**Consultation Response from KC,  
Highways Development Management**

**2023/90024 George Hotel, St George's Square, Huddersfield, HD1 1JA**

**Date Responded: 11/05/23**

Vehicular Access Site Layout Option 1
1 : 200

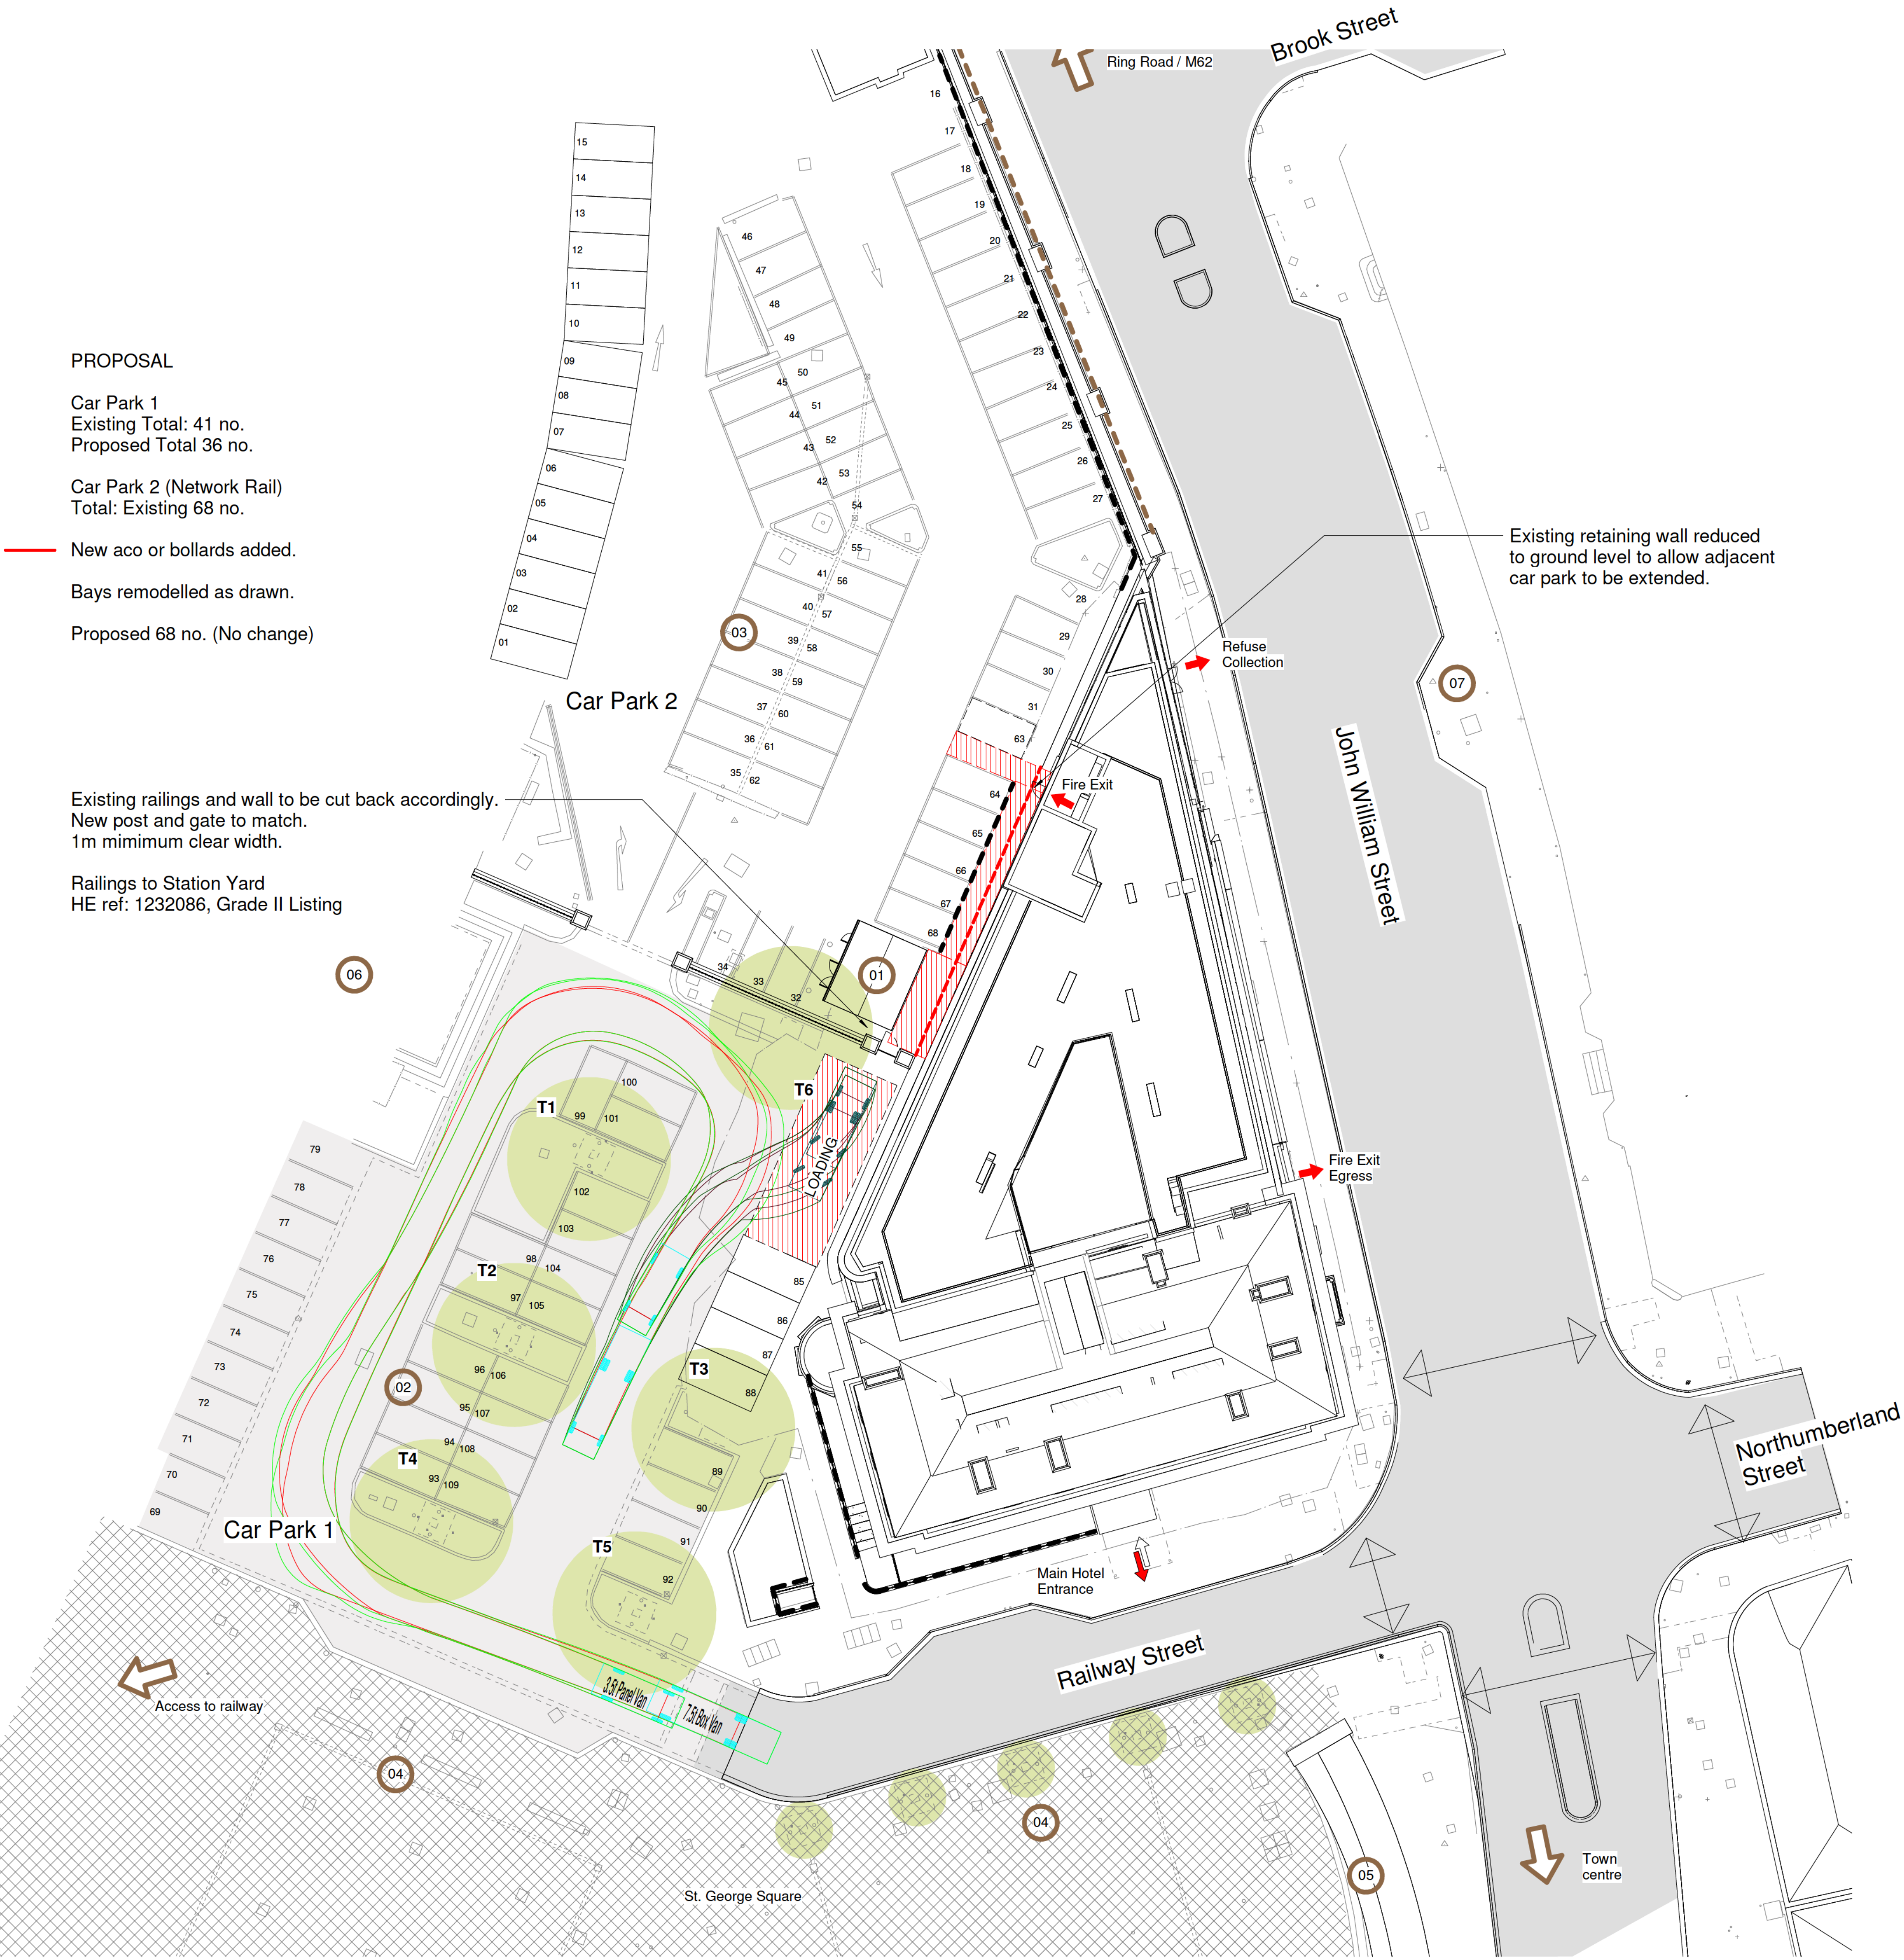
Drawing No P202 Rev P2 shows the layout of the site with a swept path analysis indicating a car parking adjacent to the west side of the site. On Drawing No 1011 P4, provided with the TS and Travel Plan, this swept path is for a 7.5 tonne box van and is indicative that servicing can take place adjacent to the site. The servicing shown on these drawings would take over approximately 5 car parking spaces from the short stay parking area to the front of the station, however the street view image seen on Google has the parking spaces cordoned off with cones and tape and so it is assumed that this servicing arrangement has occurred previously.

The drawing also indicates that waste collection would take place from John William Street, and it is noted that there is an existing dropped kerb of approximately 9m length adjacent to the doorway to the rear of the hotel. As this would not have been for vehicular access to the site it is assumed that this was created for servicing and waste collection. At this location John William Street is reduced to a single lane heading northbound (the side of the hotel and dropped kerb) with a hatched central reserve. At this location the footway is approximately 3.2m wide and we consider that, although there would be some obstruction of the footway and vehicles may need to drive over the cross hatching central reserve, refuse collection could take place from this location. However, we would like to see the production of a waste management plan that would provide details of how the waste collection would be managed, including the responsibility for the movement of waste bins to and from the premises so they are not left on street after emptying. This should be conditioned.

Before development commences, a waste management plan containing details of suitable storage, bin presentation points and access for collection of wastes from the premises hereby approved shall be submitted to and approved in writing by the Local Planning Authority. The approved details shall be provided before first occupation and shall be so retained thereafter.
